Re: **Peak Technology Campus – Initial Review Comments – SWENT Comments added 1/29  
AR CP 18-00709-A3MJ20 & AR DP 20-00865**

The following list is to address each review comment made regarding the Concept Plan and Development Plan submittal review. The referral agency comments are in italics. Our response is in bold text.

MATCH LINE (SEE SHEET 4)

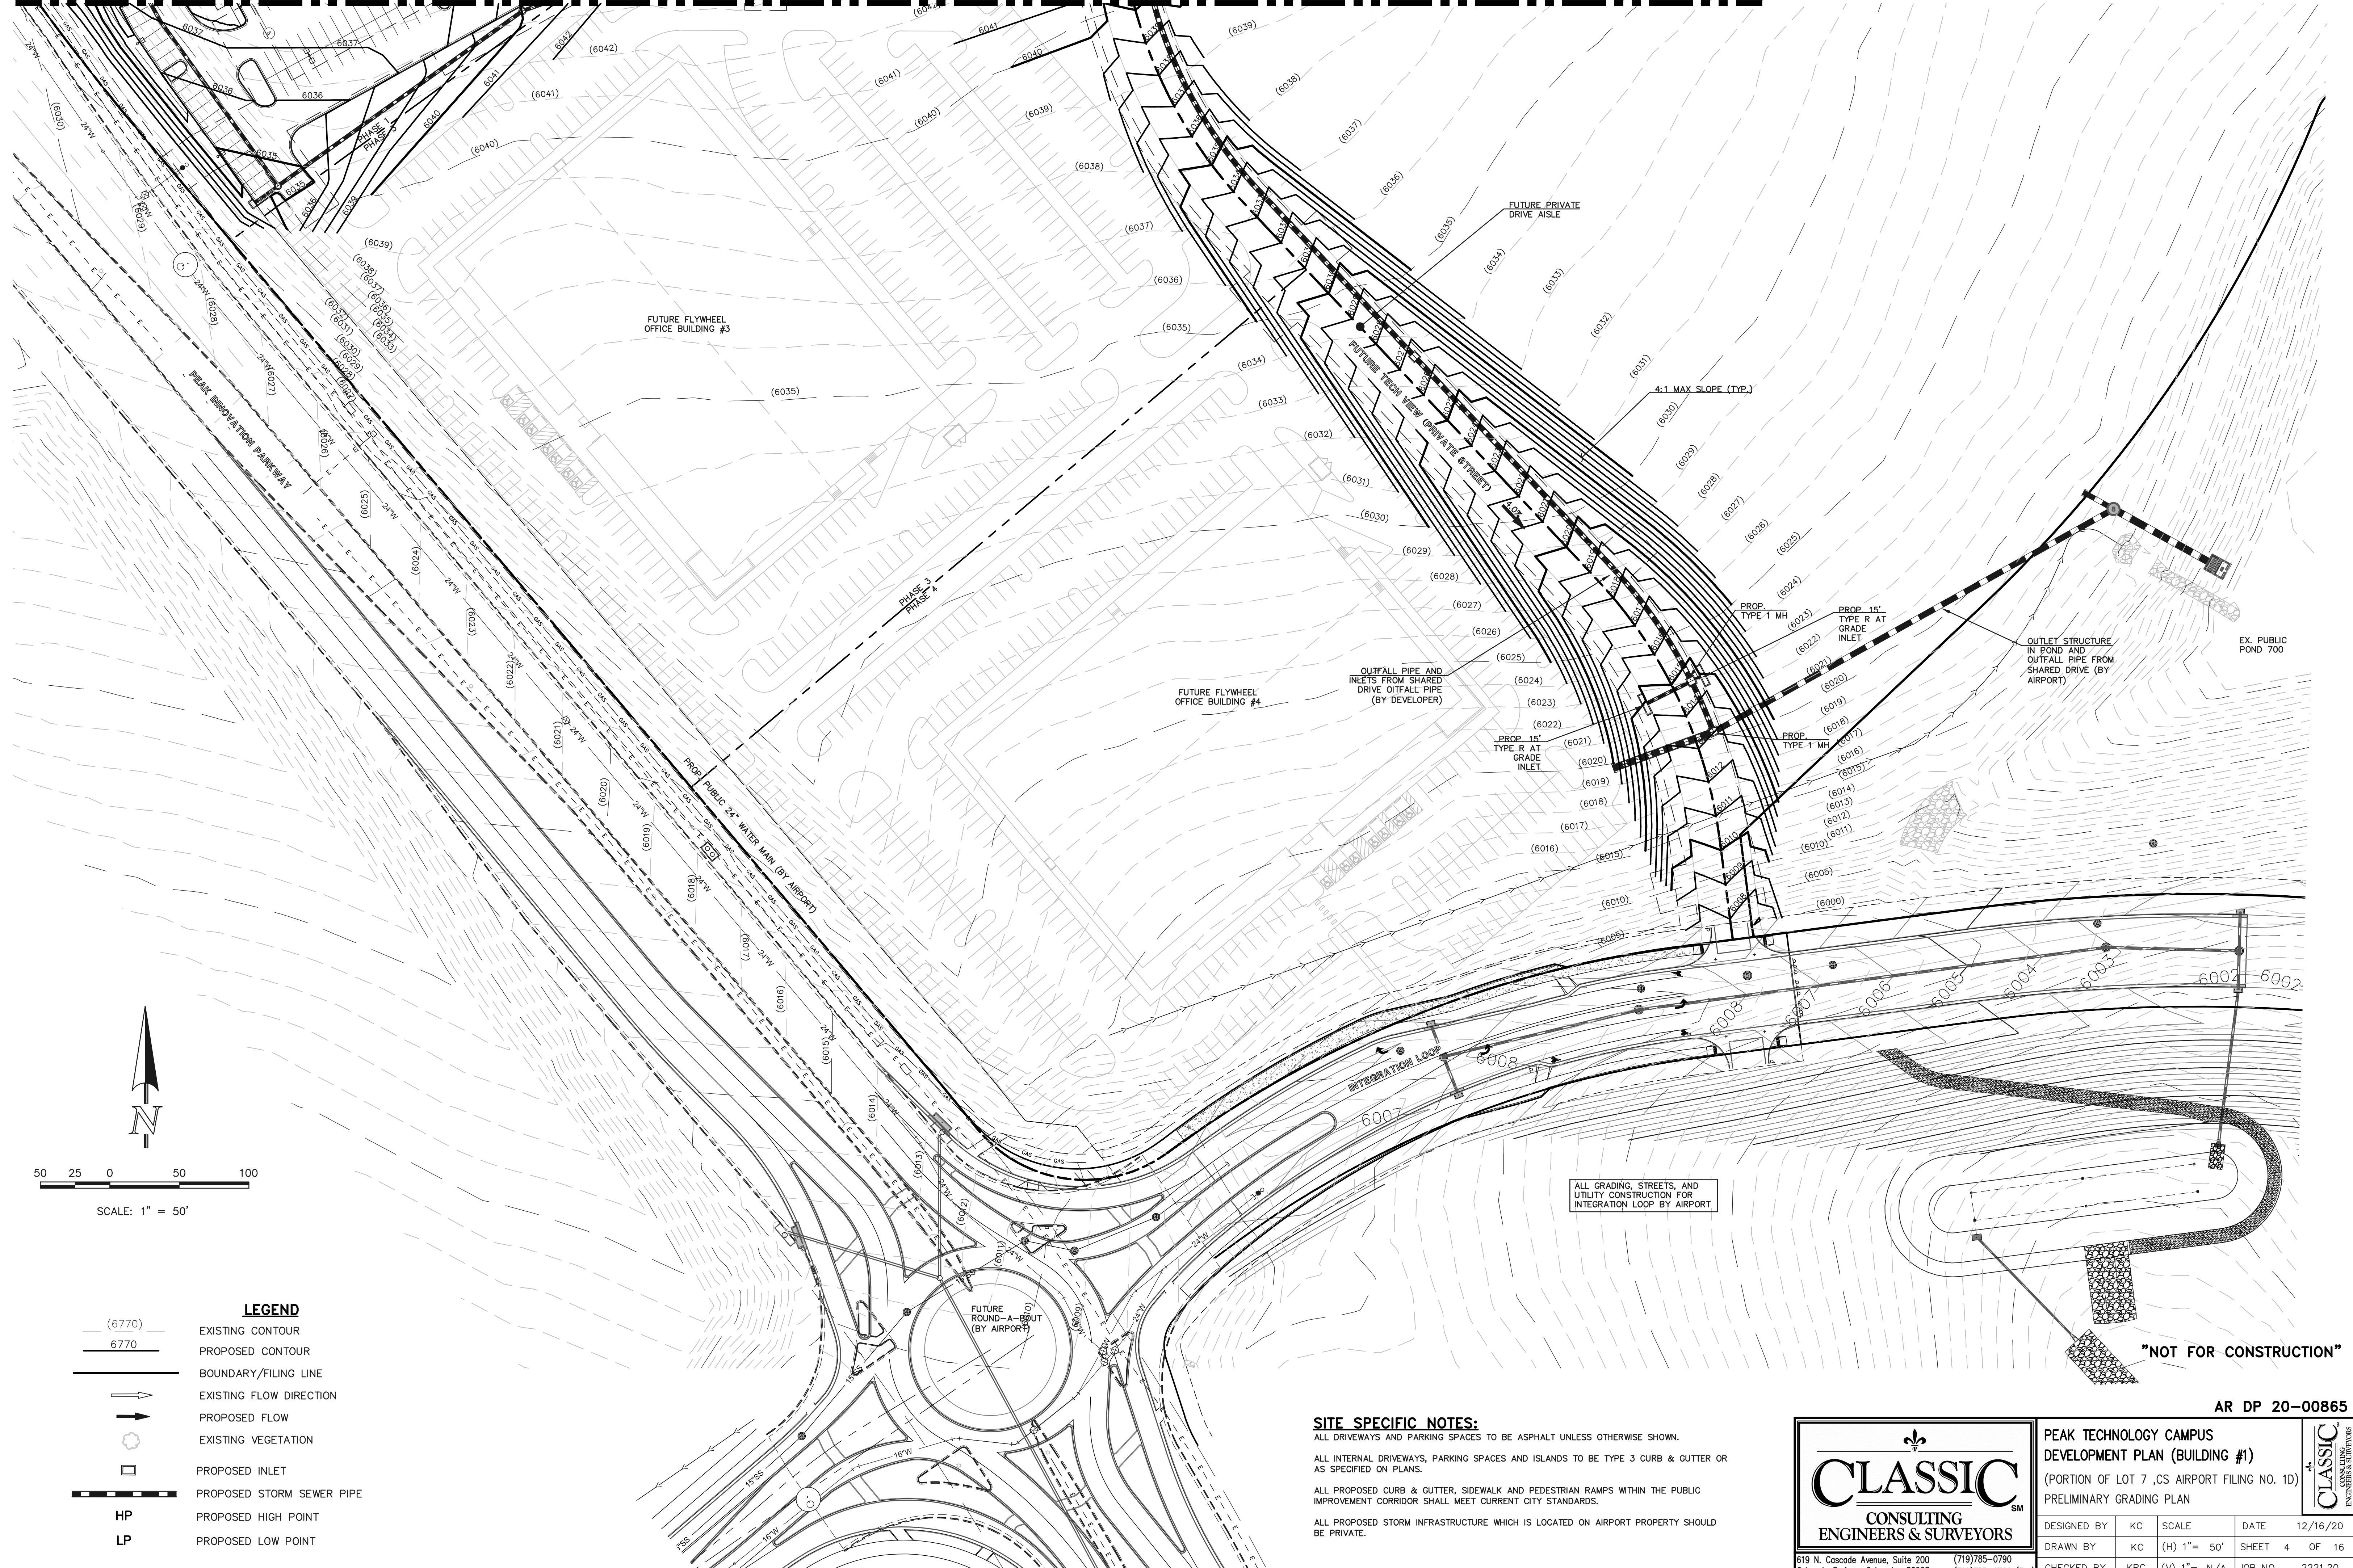
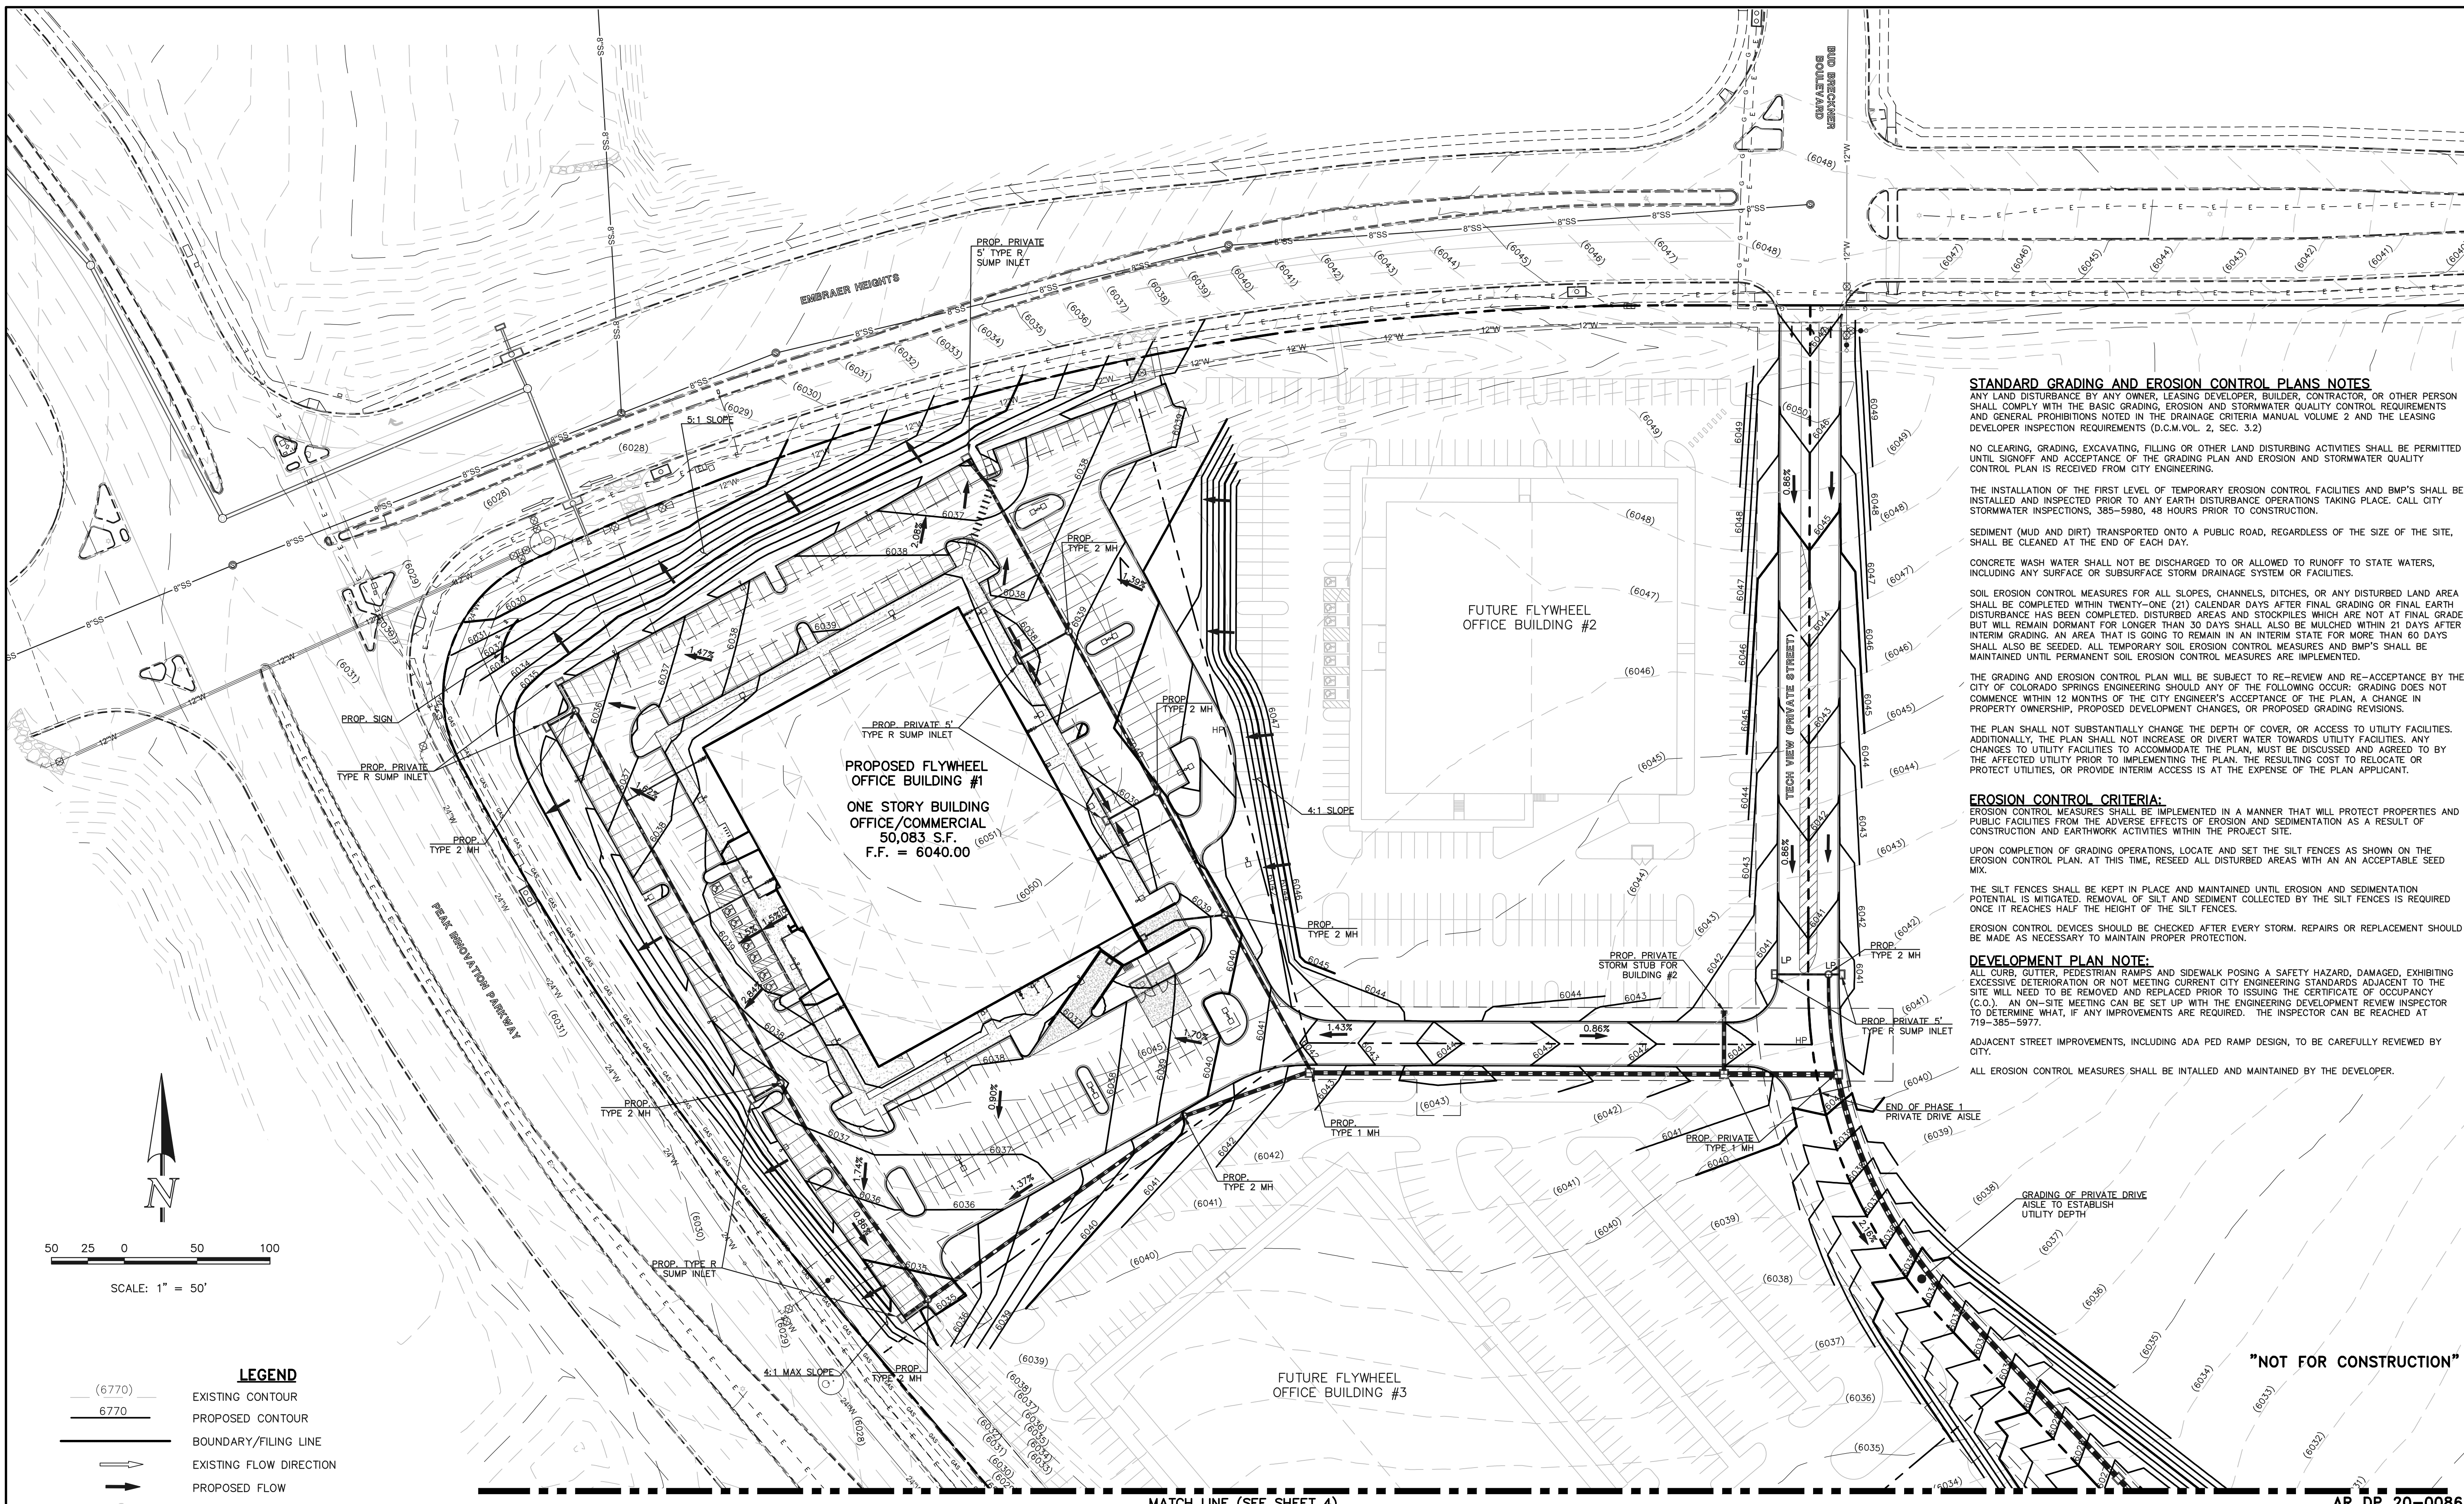
*Sheet 3 of 16:*

- *Within Standard Grading and Erosion Control Plans Notes in first paragraph replace, “the owner inspection requirements” with “the leasing developer inspection requirements”.*

- *Within Site Specific Notes, replace “right-of-way” with Public Improvement Corridor.*

**Response:** Revised as requested.

**Response:** Revised as requested.

DESIGNED BY KC SCALE DATE 12/16/20
DRAWN BY KC (H) 1" = 50' SHEET 6 OF 16
CHECKED BY KRC (V) 1" = N/A JOB NO. 2221.20

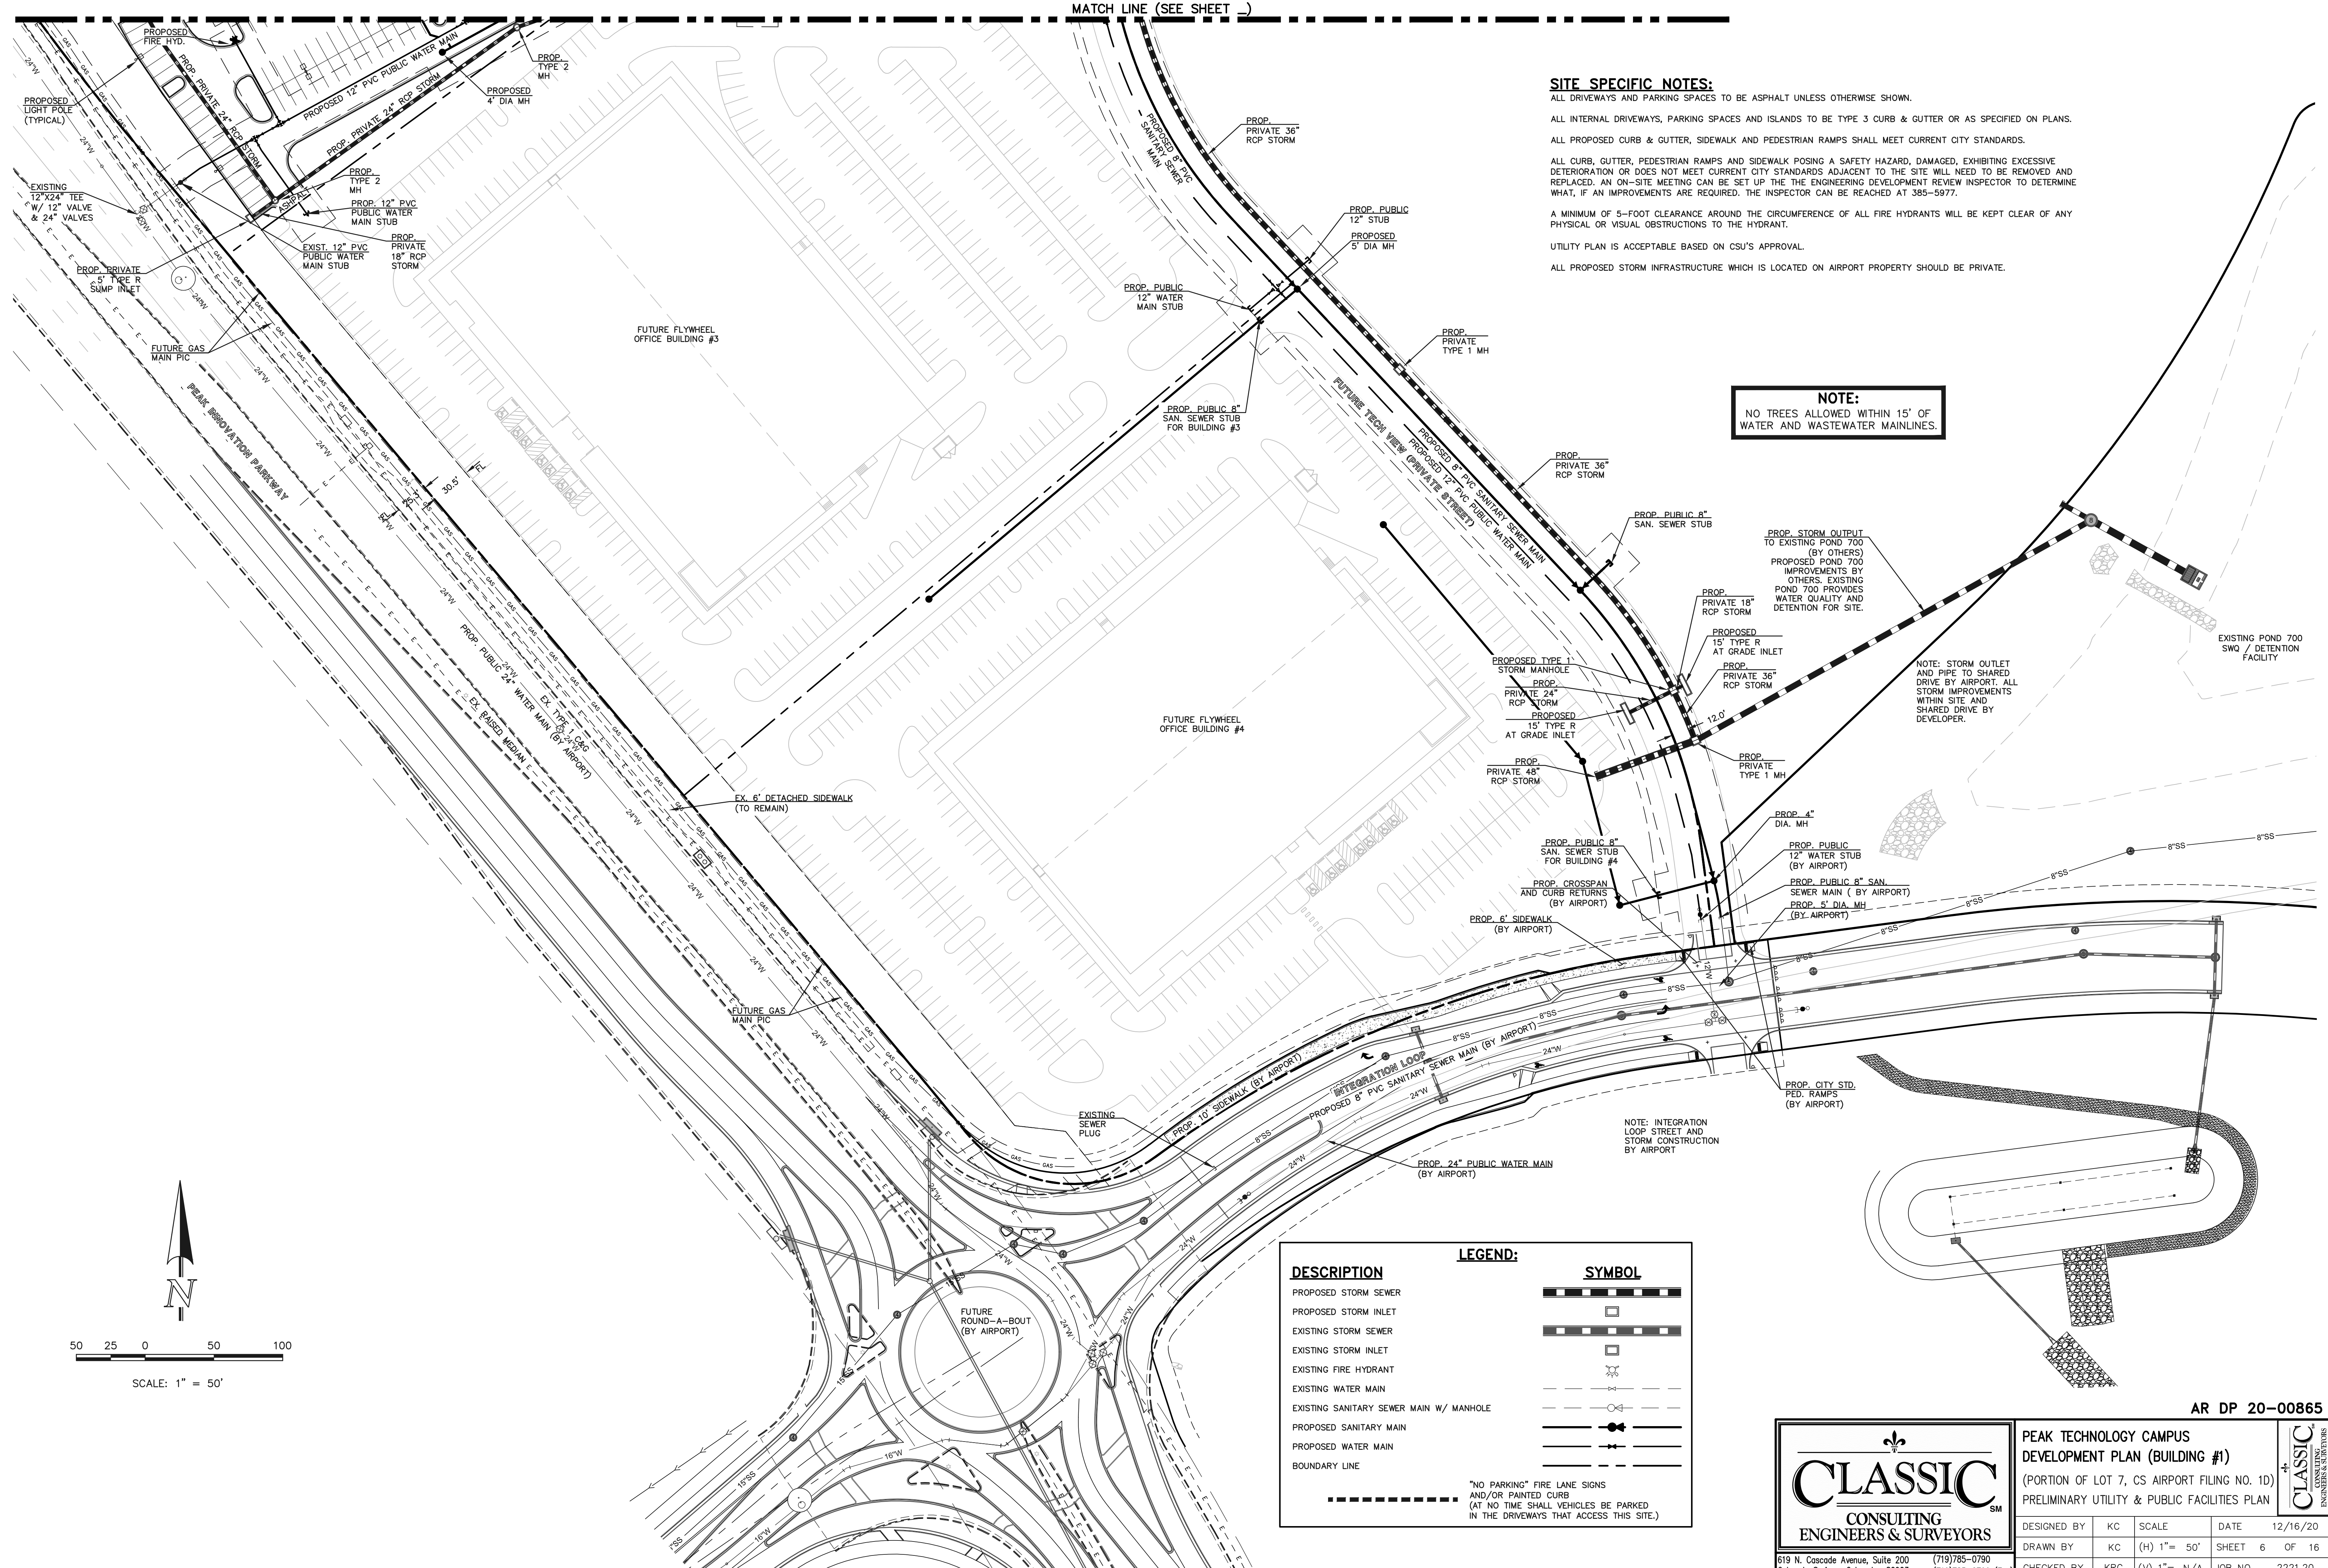
Sheet 6 of 16:

- Remove (BY AIRPORT) at the Proposed 12" Public Water stub

- Remove (DEVELOPER INSTALLATION REIMBURSEMENT BY AIRPORT) at the Proposed Public 12" Water Main within the future private drive aisle

**Response:** Revised as requested.

**Response:** Revised as requested.
